Our Ref: R/92/18/HH

**Town & Country Planning Act 1990 (as amended)
Town & country Planning (Development Management Procedure) (England) Order 2015
Application for Planning Permission for Works or Extension to a Dwelling**

Development Extend fence along side of property, new fence to front of property in front garden & brick wall to front of property
Location 91 Broadmark Lane Rustington

91, Broadmark Lane, Rustington, West Sussex, BN16 2JN

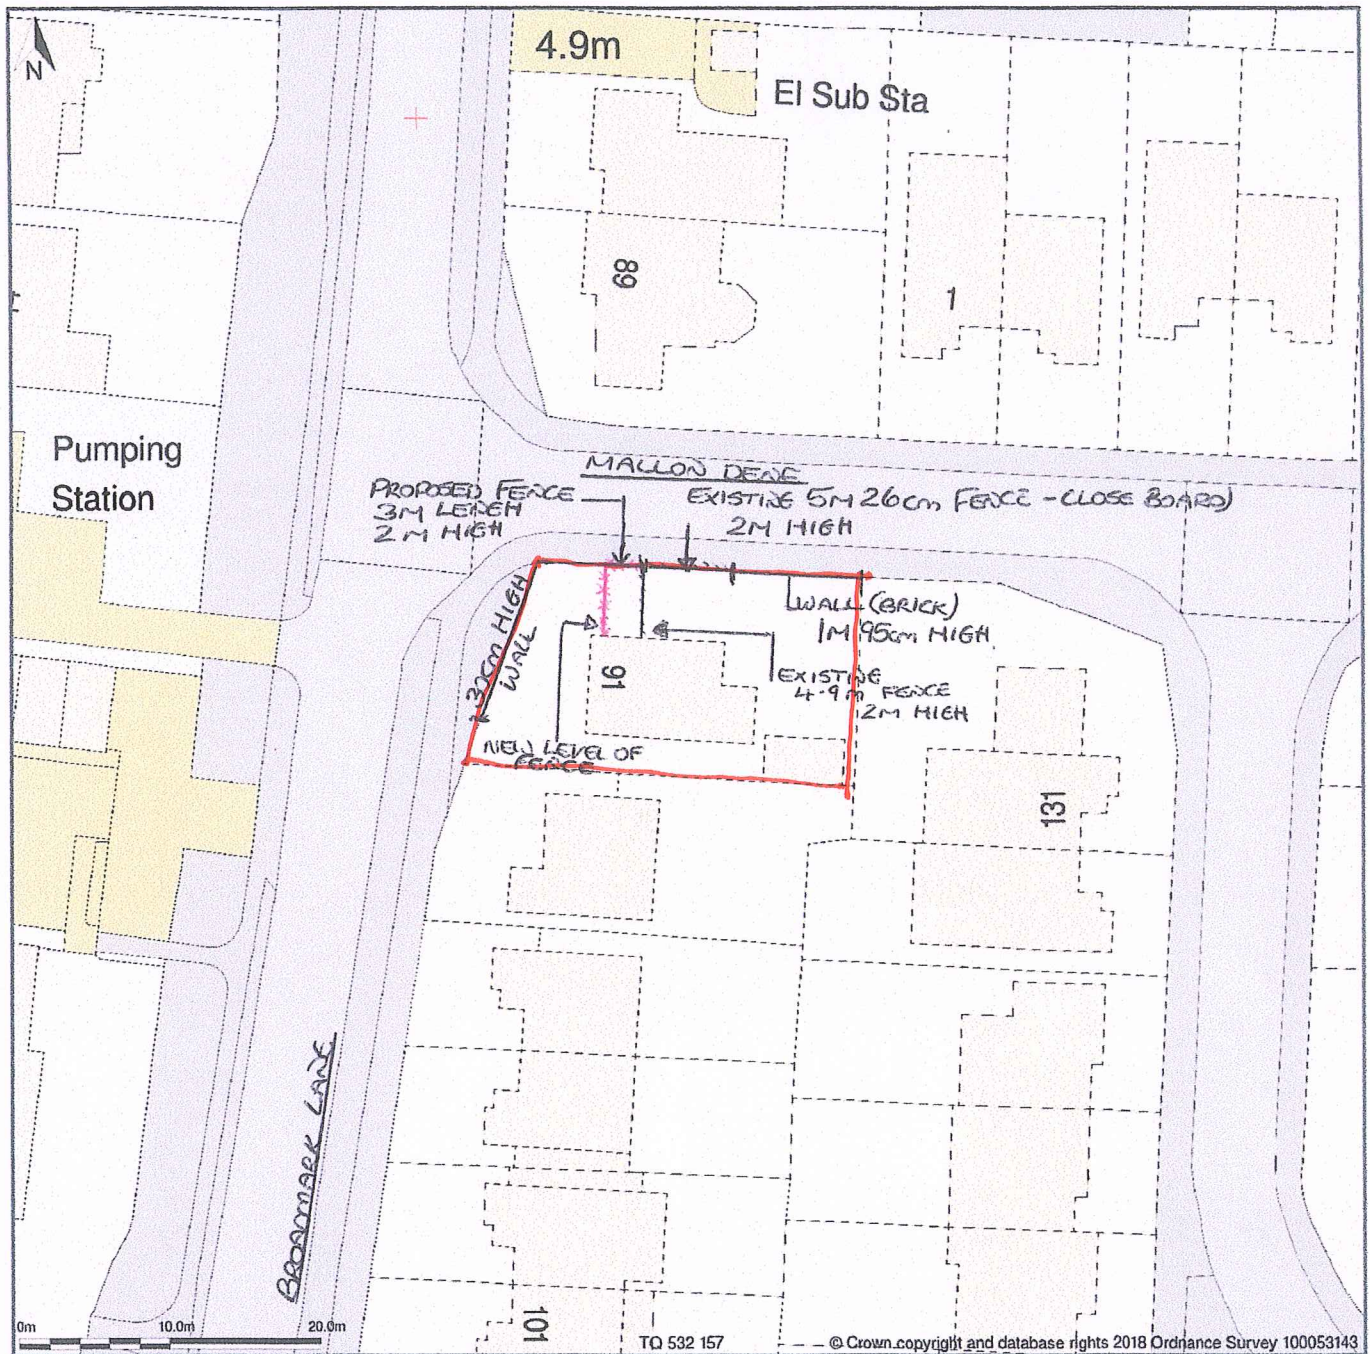
Block Plan Amend

Please submit 1 electronic or 3 paper copies of a block/site plan at a scale of 1:500 or 1:200. Further details of what must be included on the plan can be found in the National Validation Requirements. Please provide a north point and a scale.
